A47 Blofield to North Burlingham

Scheme Number: TR010040

Volume 8
8.13 Statement of Common Ground
with National Highways
and Blofield Parish Council

Statement of Common Ground – Blofield Parish Council

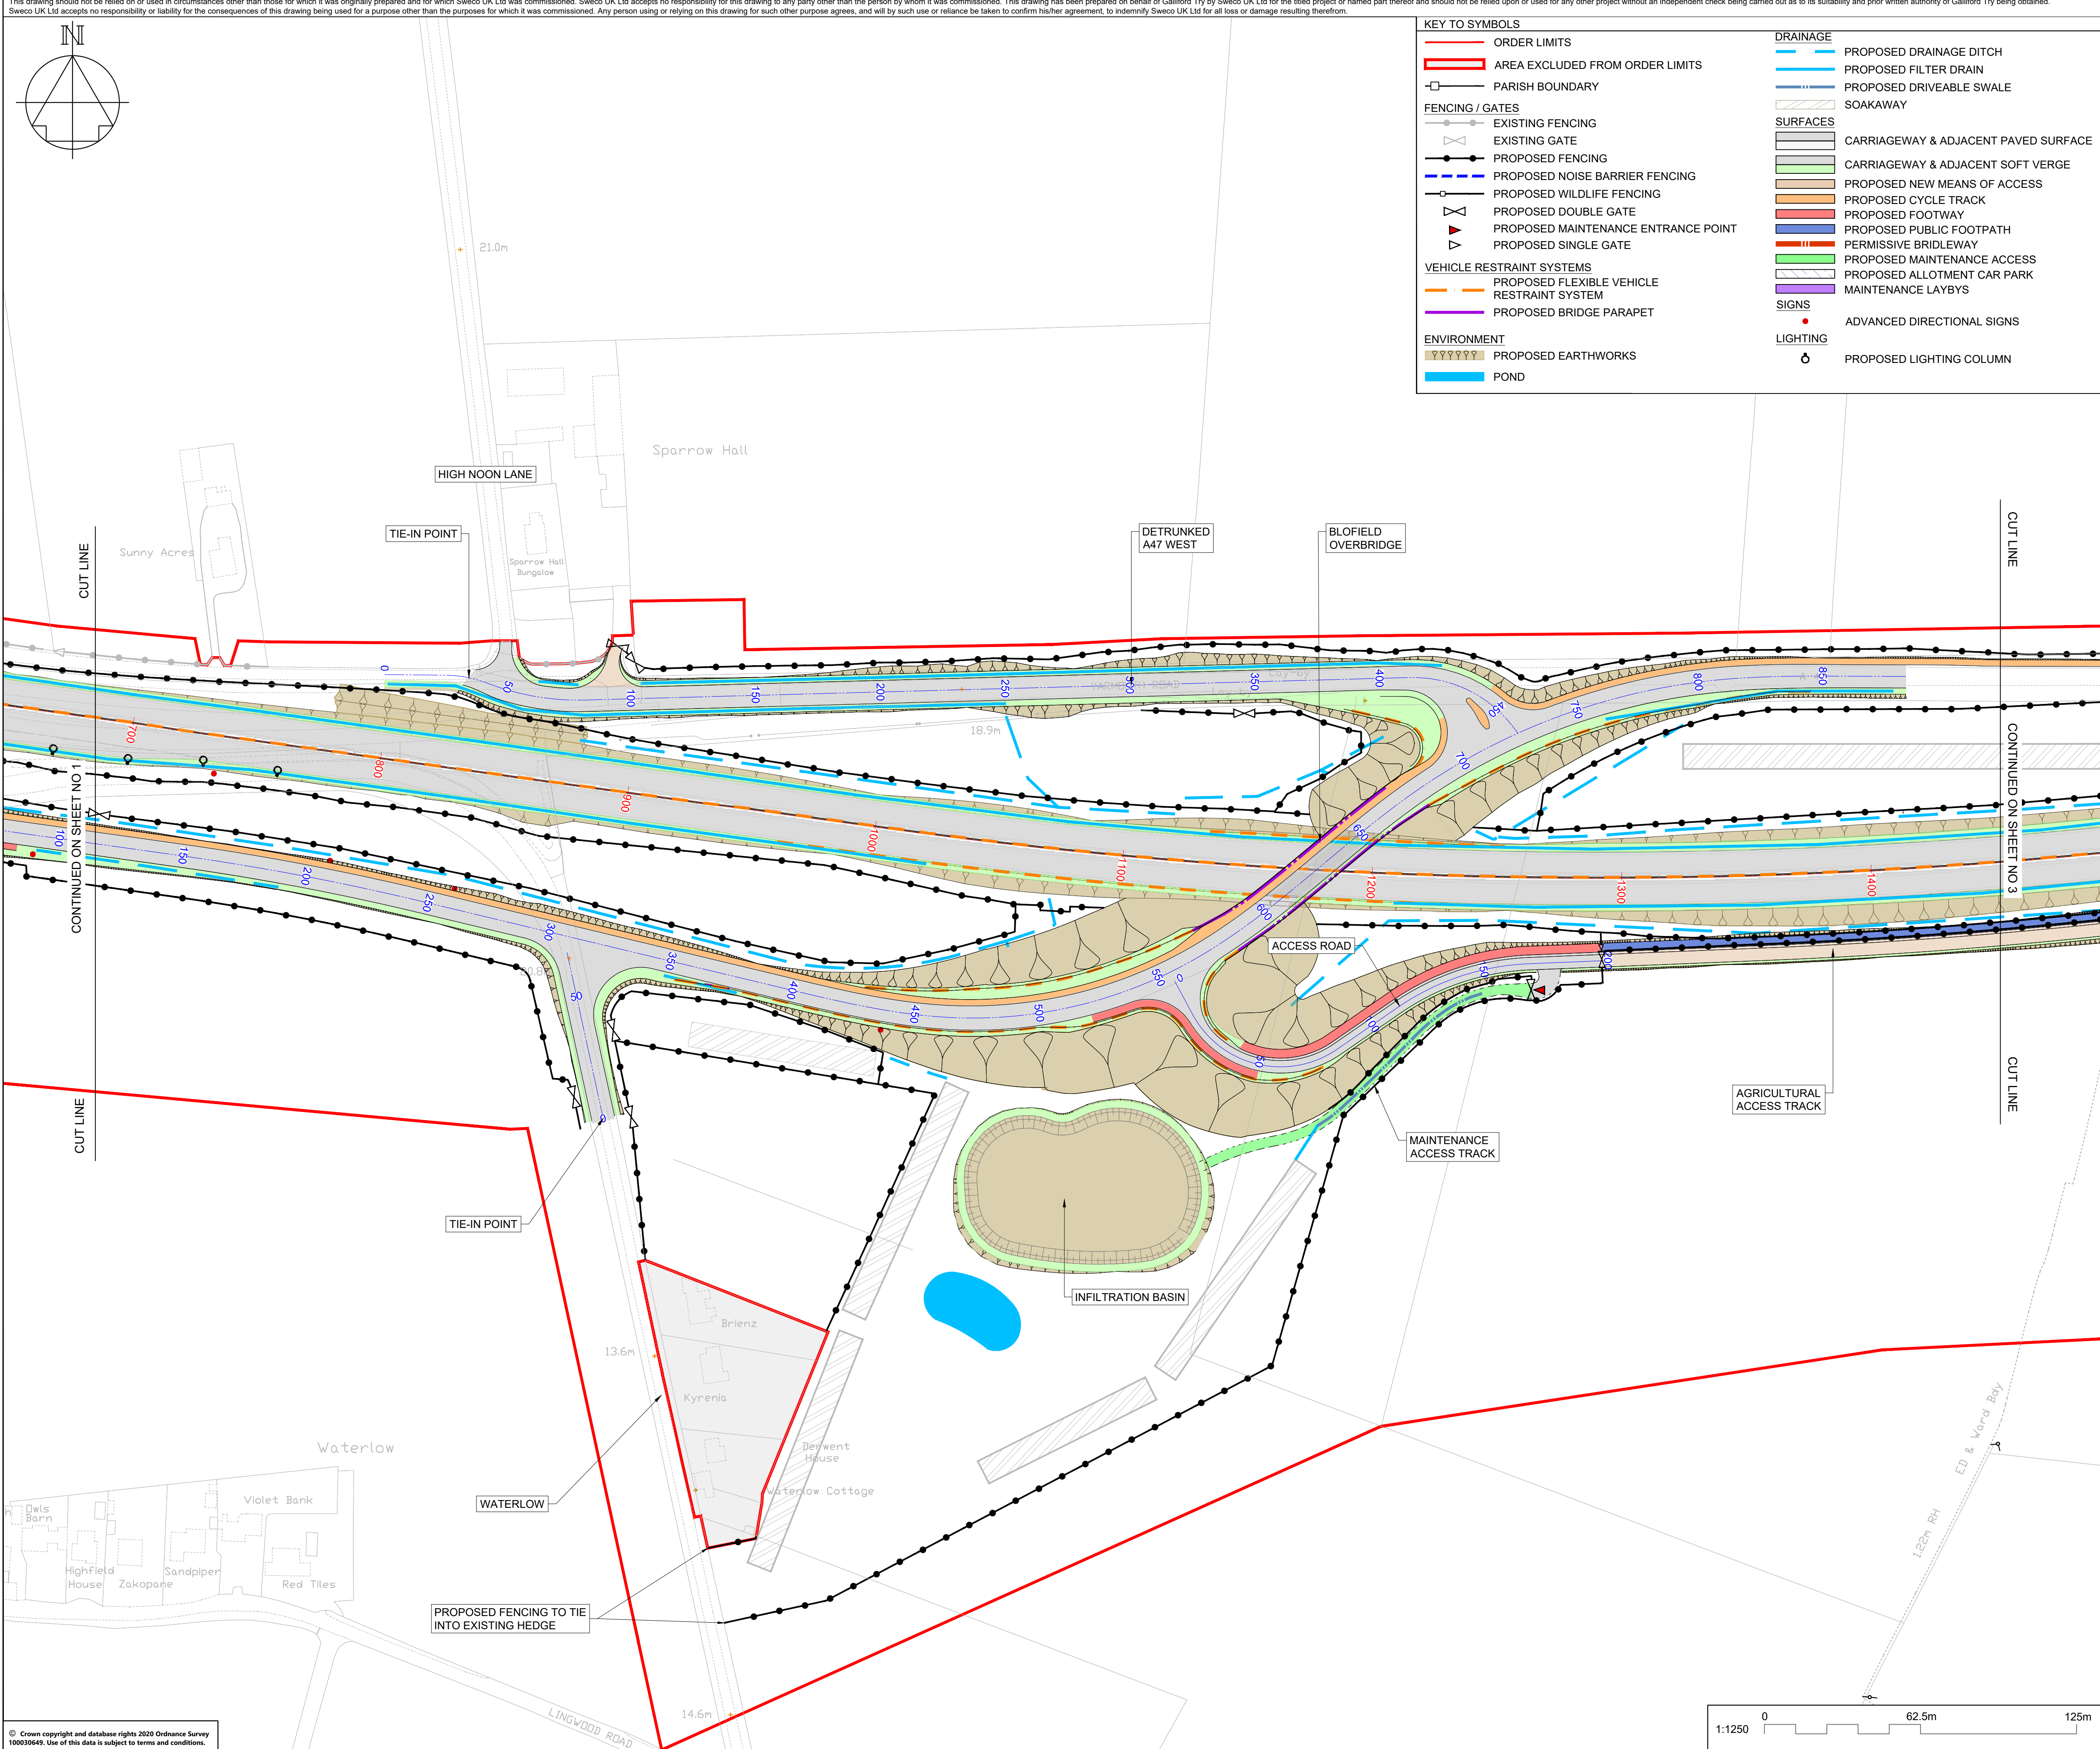
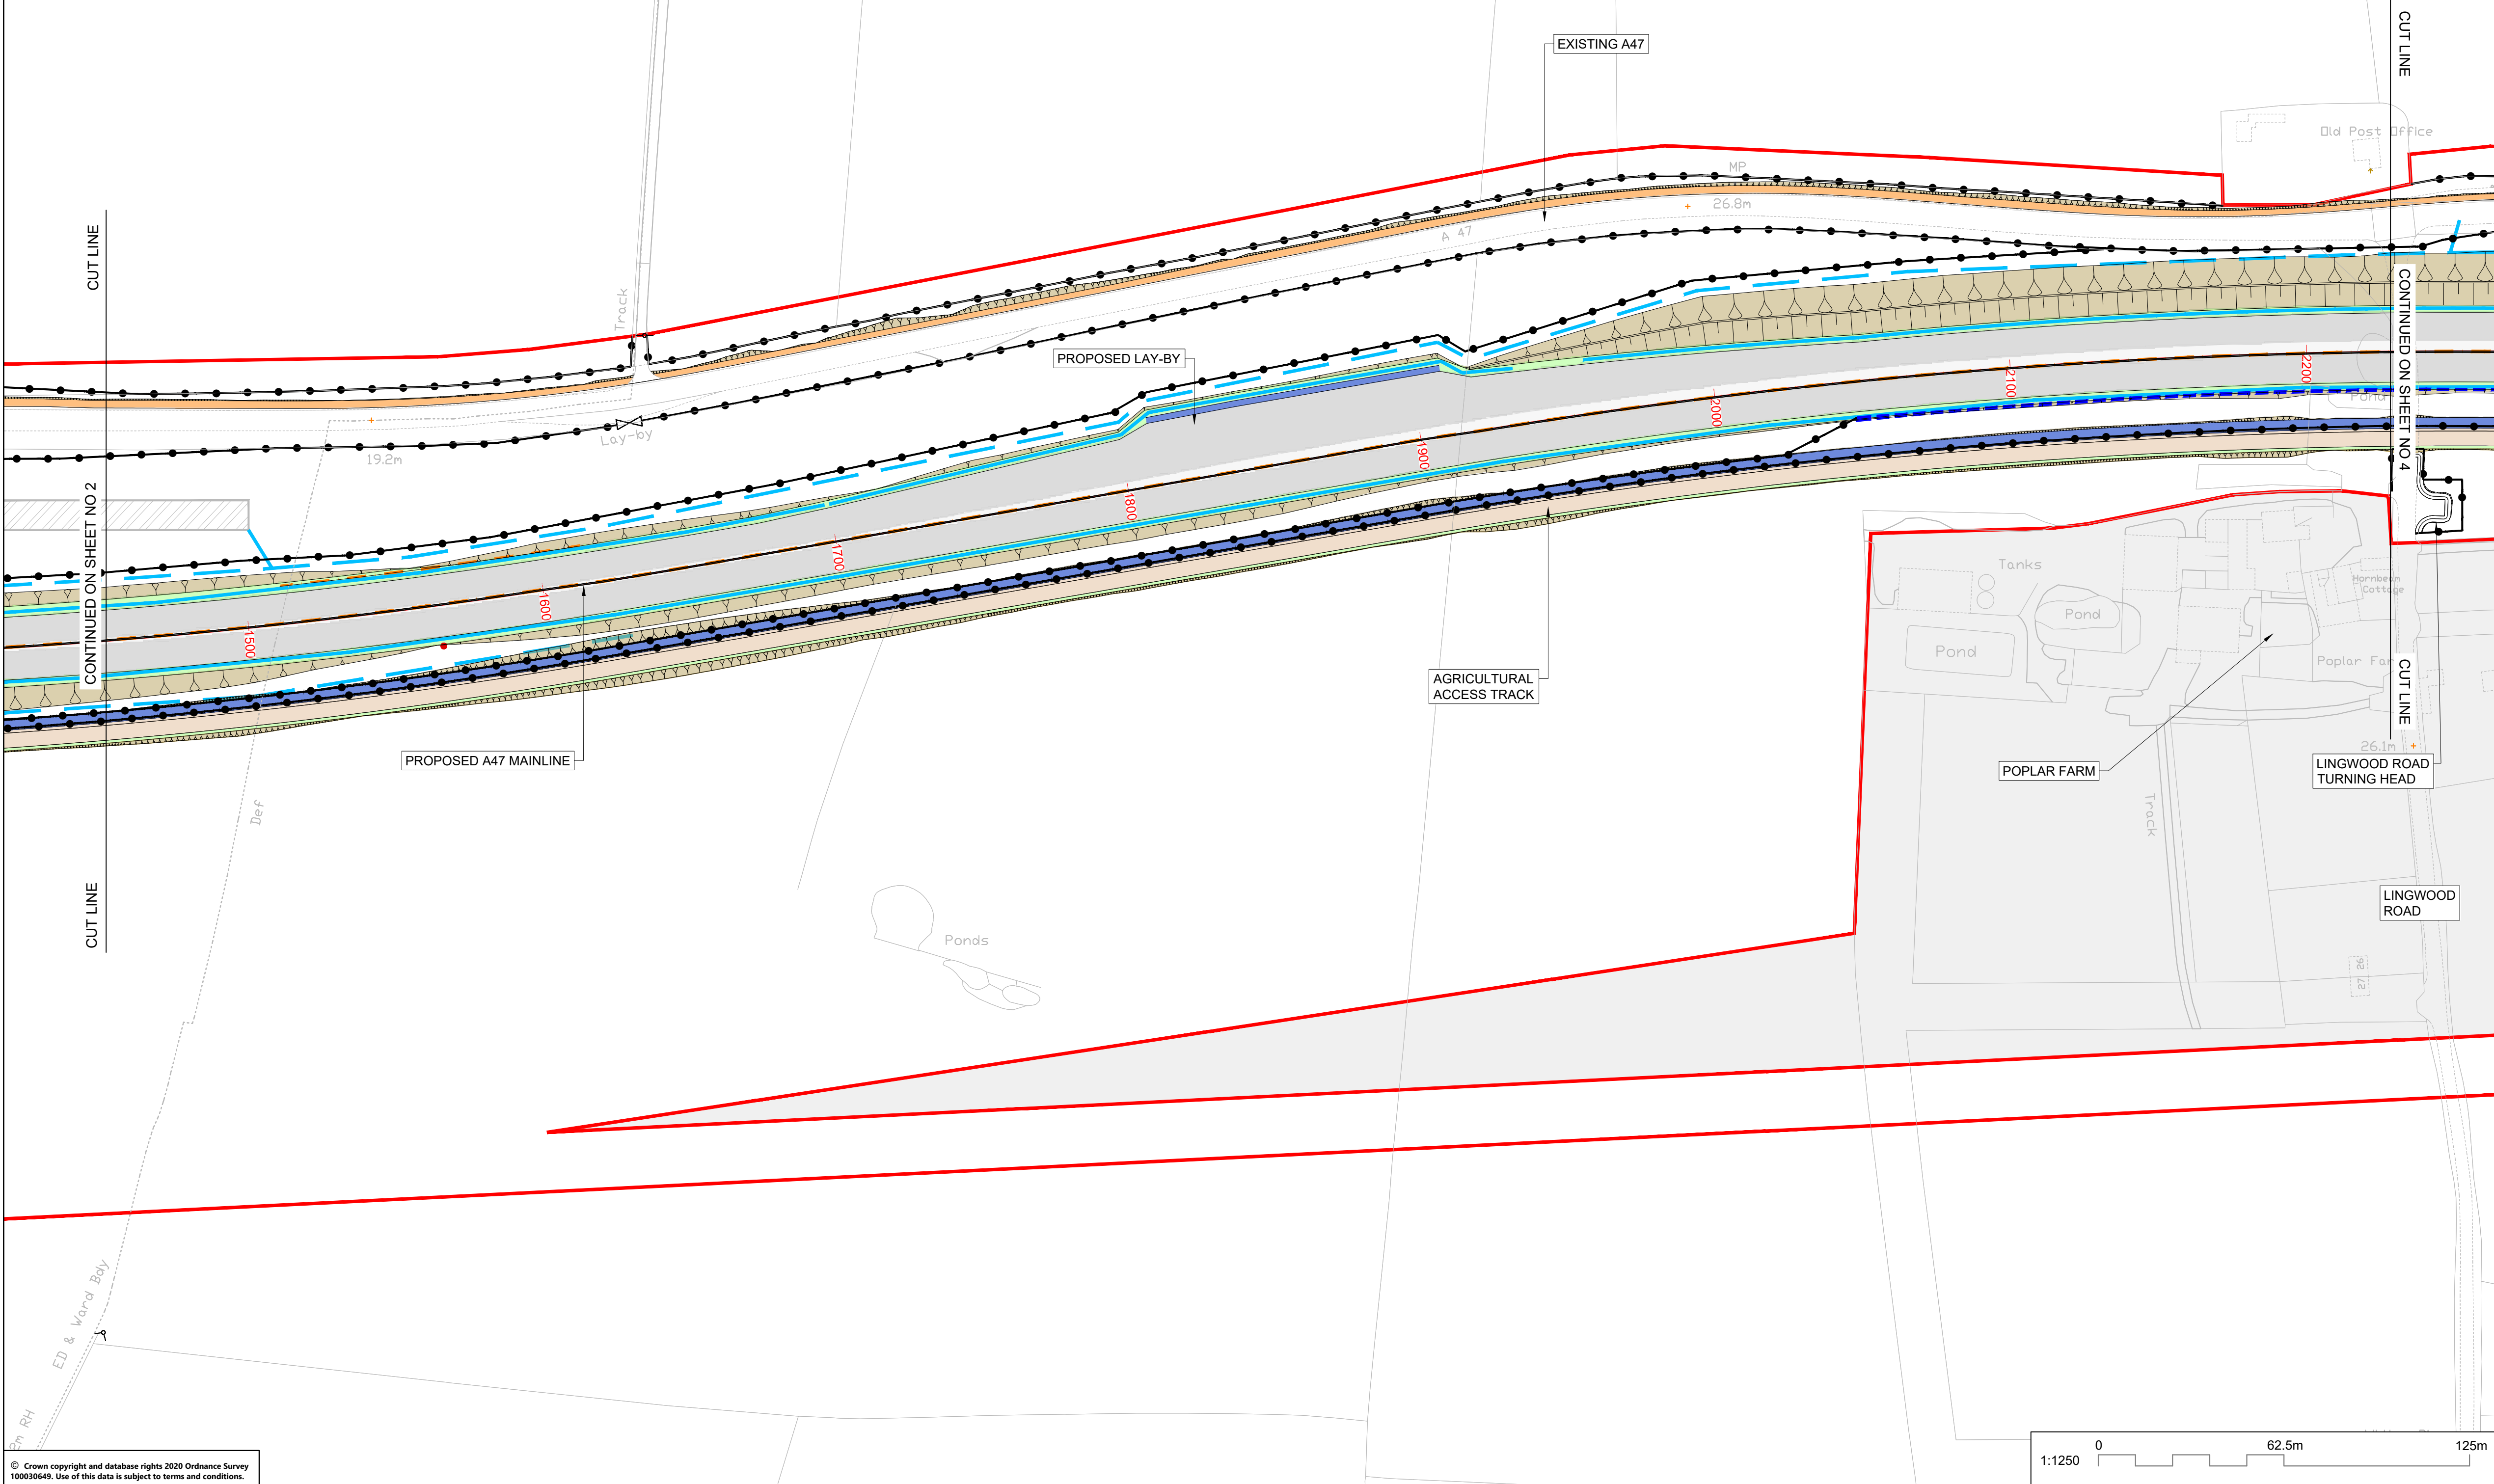
Road Lighting	Letter from BPC in Appendix C, Appendix H & Appendix I	2.6 General Arrangement Plans The proposed 20 lighting columns would be in contradiction of the Blofield Neighbourhood Plan Environment 5 Policy regarding Dark Skies. If the proposed junction was amended as per our suggestion at the beginning of this document, then the junction lighting would not be in contradiction to our local plan policy.	As described in the Scheme Design Report (REP1-046) lighting is proposed at the Yarmouth Road as road safety mitigation. The lighting will be LED and include back shields, where appropriate, to limit light spill. The modified junction arrangement as proposed by Blofield Parish Council is not a technically viable solution. Whilst Option B, considered in the Scheme Design Report (REP1-046) may not require lighting, it would have other environmental impacts resulting from the increased land take and additional construction.	Under discussion

Issue	Document Reference	Blofield Parish Council Comment	Applicant's Response	Status	Date
			The provision and assessment of lighting in the ES Chapter 7 (APP-045) and the Lighting Assessment contained in Appendix 7.8 (APP-085) assume the worst-case scenario and if alternative solutions can be found to improve the visibility of the junction without the need for lighting the lighting may be removed during detailed design.		
Road Lighting	Email from BPC in Appendix E	There are also a lot of street lighting columns which is against the dark skies policy of the council.	See response above regarding street lighting.	Agreed	11-Nov-21
Hedgerows	Letter from BPC in Appendix C	2.9 Hedgerow Plans The Council is disappointed that there appears to be limited new hedging being planted to offset the hedging being removed.	The hedgerows to be provided are shown on the Masterplan (REP7-011). The scheme results in a biodiversity net gain of greater than 40%.	Agreed	11-Nov-21
